**KIRKLEES METROPOLITAN COUNCIL  
INVESTMENT & REGENERATION SERVICE**

**DELEGATED DECISION TO DETERMINE PLANNING APPLICATIONS**

| Site Address:         | 7, Brier Hill View, Bradley, Huddersfield, HD2 1JQ                  |
| Description:          | Erection of single storey rear extension and associated alterations |

Drawing Title
Planning Drawing

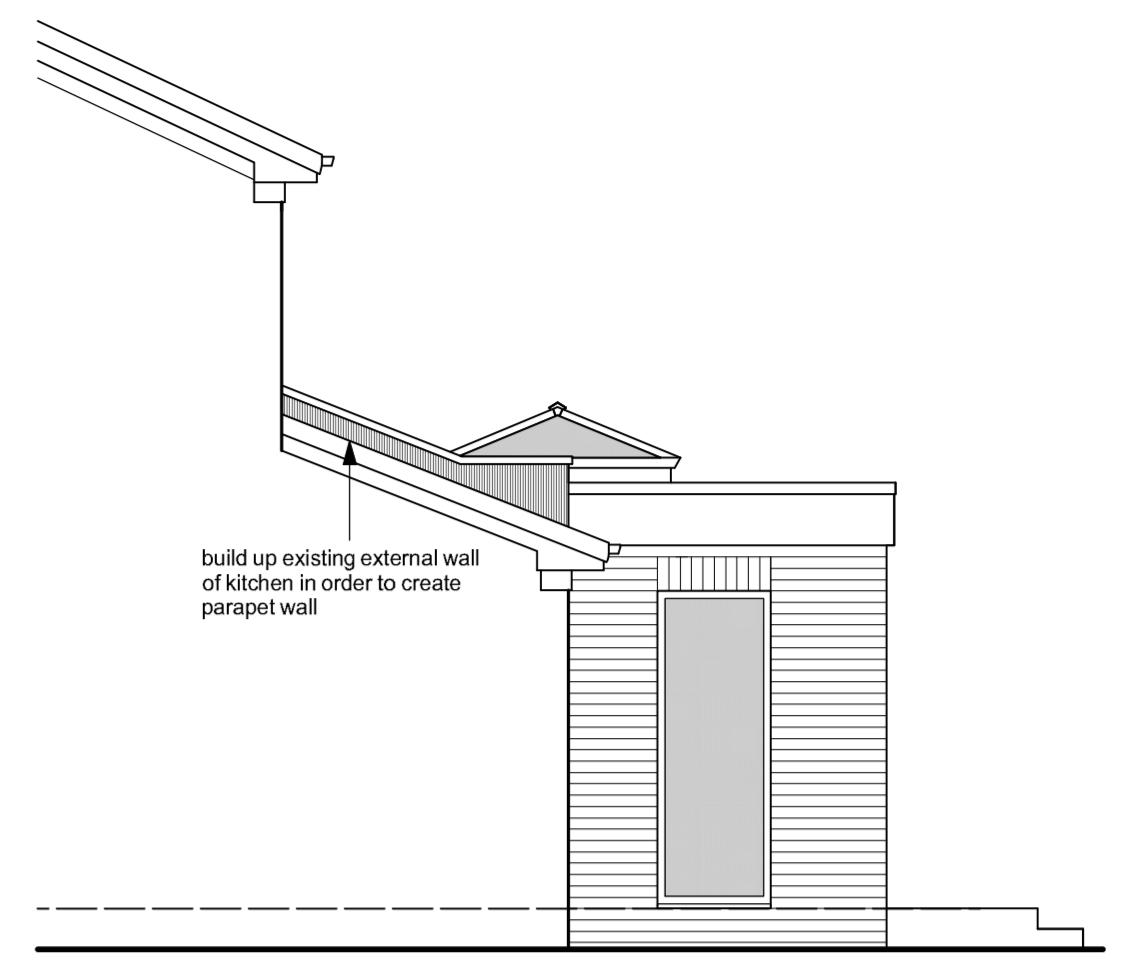
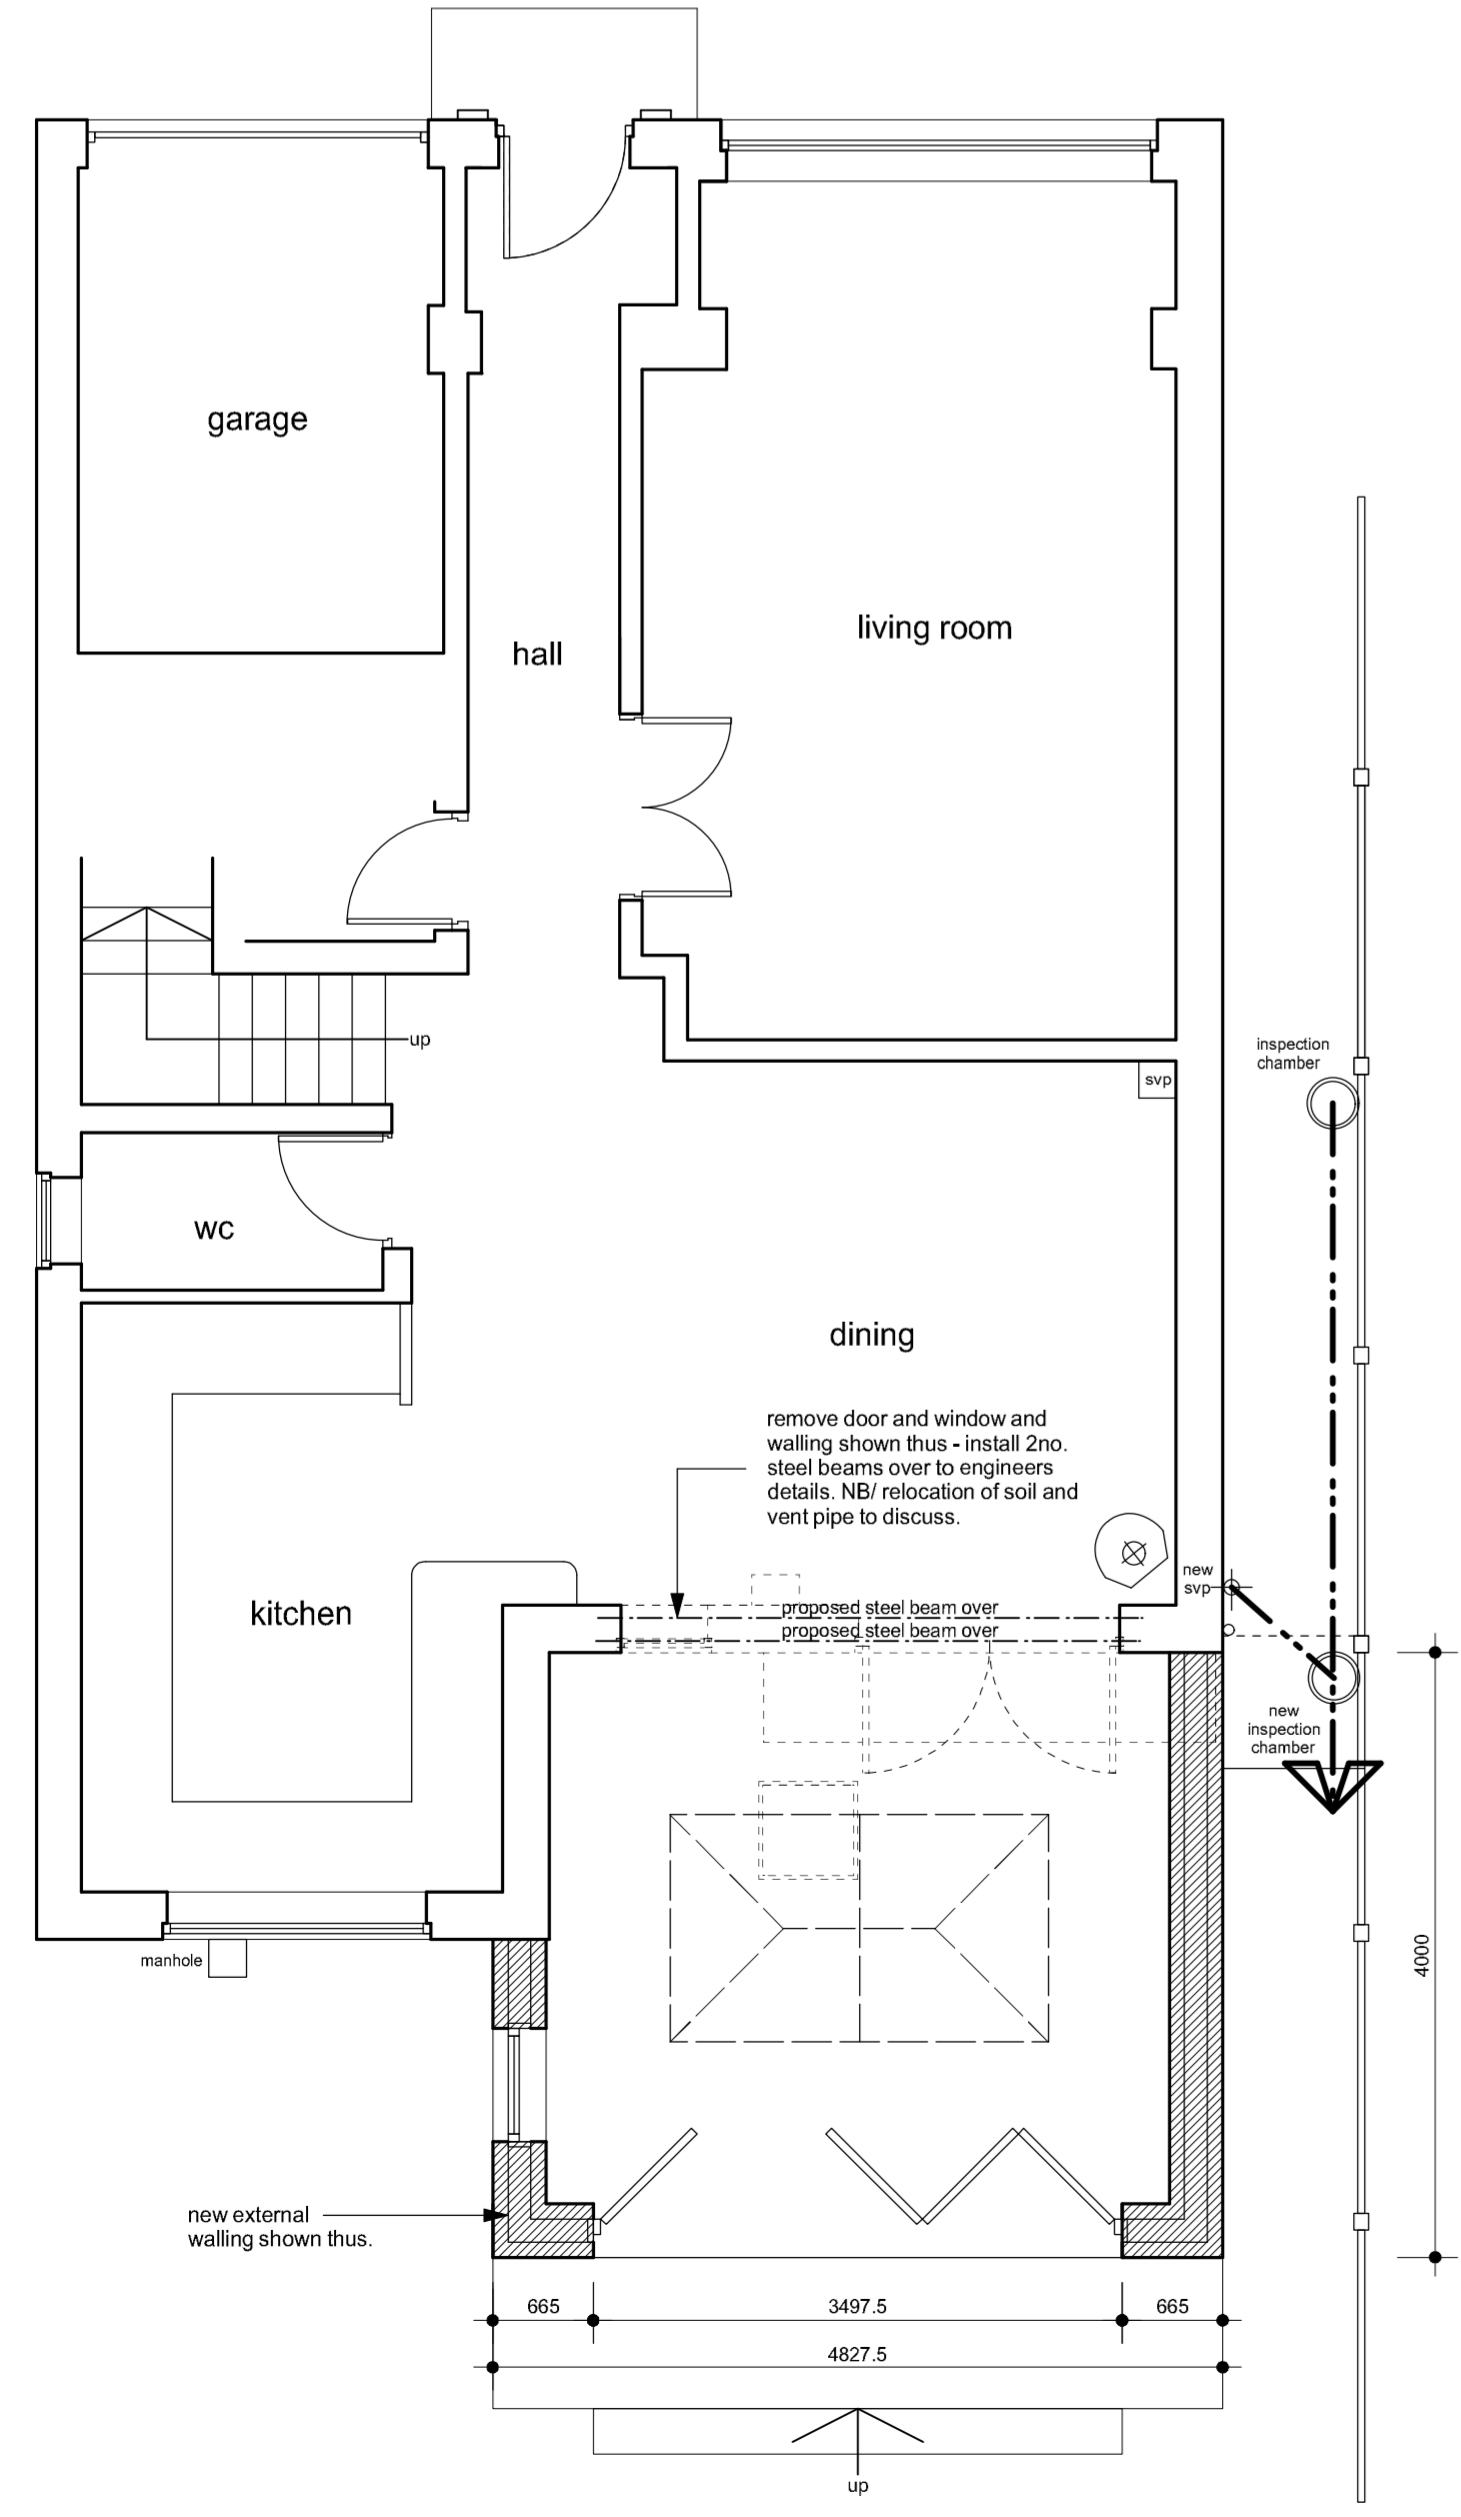
| not exceed 4 metres in height;  | Yes – The extension does not exceed 4m in height. The extension has a flat roof and has an overall height of 3m. |  |
| not project out more than 3 metres from the rear wall of the original house for semi-detached and terraces houses or by 4 metres for detached properties; | Yes – The application site is a detached dwelling, and the proposal does not project beyond 4m.                  |  |
| retain a gap of at least 1 metre from a property boundary, such as a wall, fence or hedge.  | Yes – extension retains a 1m gap from the side boundaries.   |  |

|  | <b>the Kirklees Local Plan and the NPPF</b>  |  |   |
|--|--|--|---|
| Window proportions                             | <ul style="list-style-type: none"> <li>• KDP 1 and 2 of the SPD</li> <li>• Policy LP24 Design (a), (c)</li> </ul>  | Modest size windows in rear extension, including roof lantern and northwest facing window  | ✓ |

|                             | <ul style="list-style-type: none"> <li>and (d) of the KLP</li> <li>Chapter 12 of the NPPF</li> </ul>                                | along the side elevation, which would be in-keeping with existing building.     |   |
